From: Mundy, Ben - Oxfordshire County Council <Ben.Mundy@Oxfordshire.gov.uk>
Sent: 22 June 2022 16:40
To: DC Support; Katherine Daniels
Cc: Transport CDC Minor
Subject: 22/01599/DISC Land Approx 1 Mile From J9 East Of M40, Part Of M40 Through Chesterton Parish, Chesterton

Planning Application: 22/01599/DISC

Description: Discharge of Conditions 6 (colours and materials of any water slide, wolf, or other external built feature), 24 (footpath specification details) and 25 (Construction Traffic Management Plan) of 21/04158/F

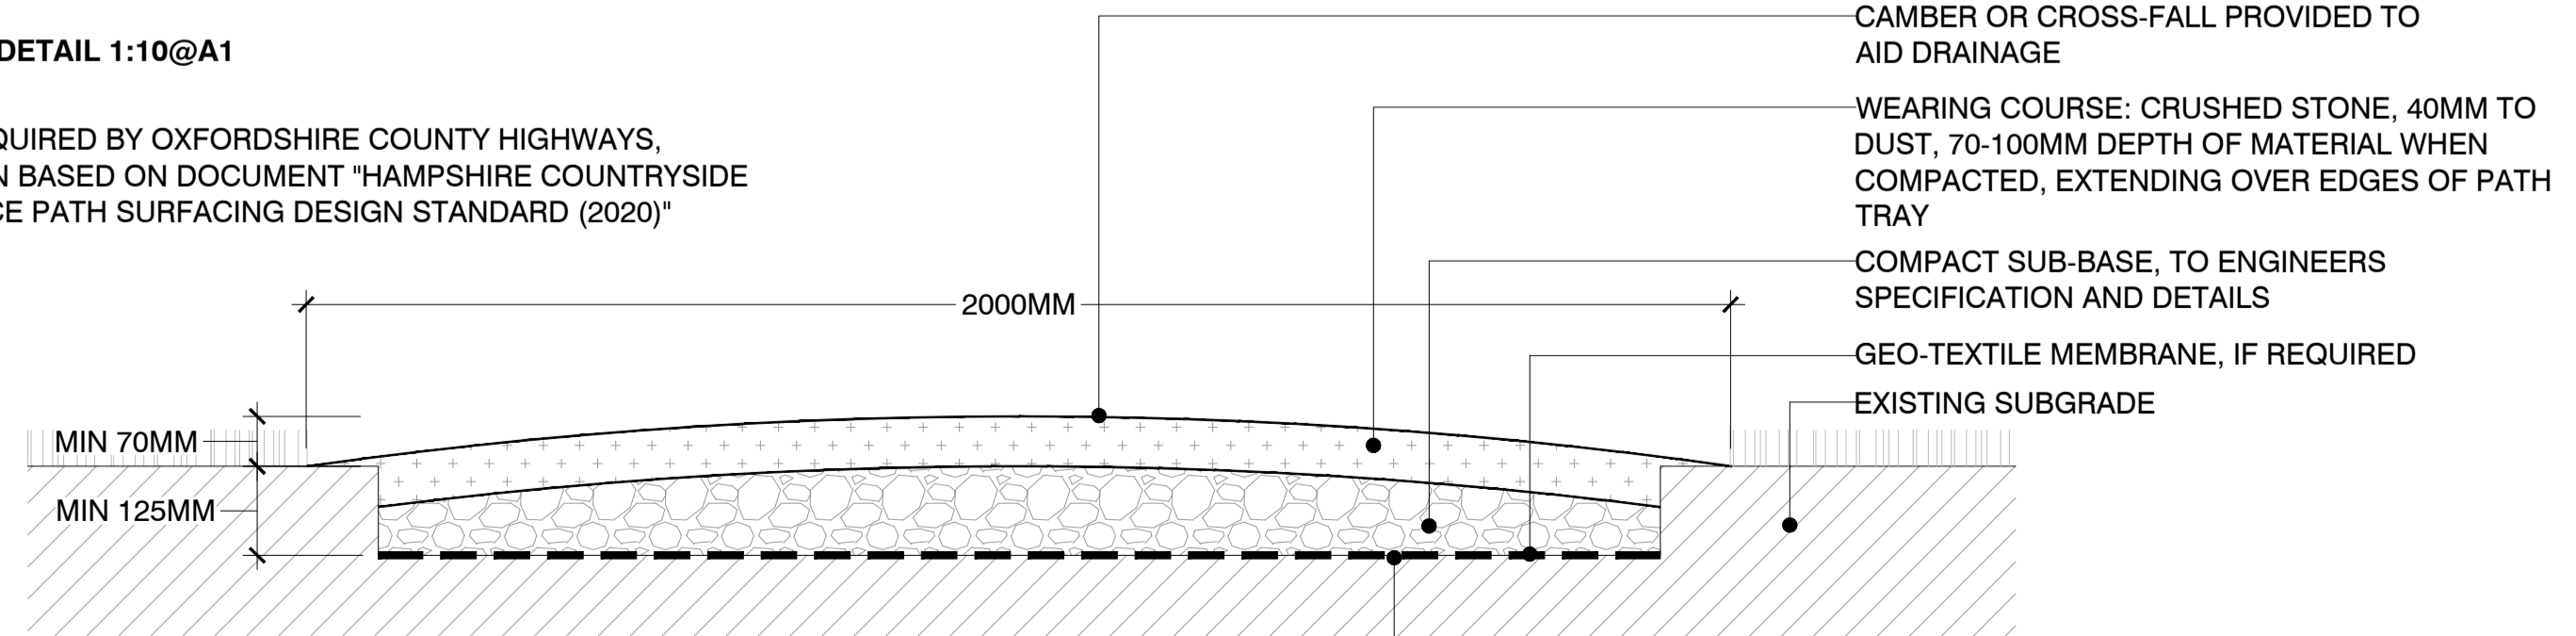
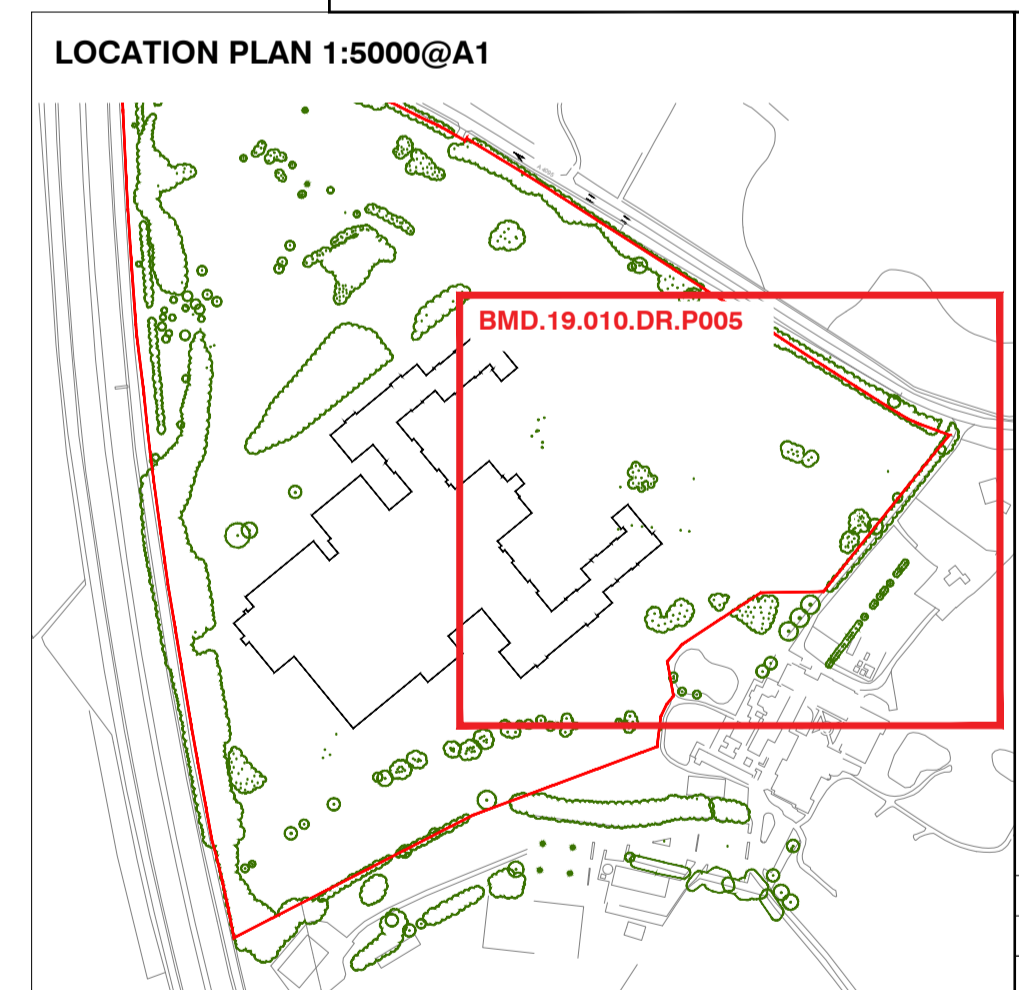
The construction of the public right of way using gravel is likely to have severe detriment to vulnerable people or people pushing buggies. Therefore it is recommended that the public right of way is constructed with materials that are more suited to people within those categories, whilst maintaining the method of sustainable drainage. For example, Permeable Pathing.
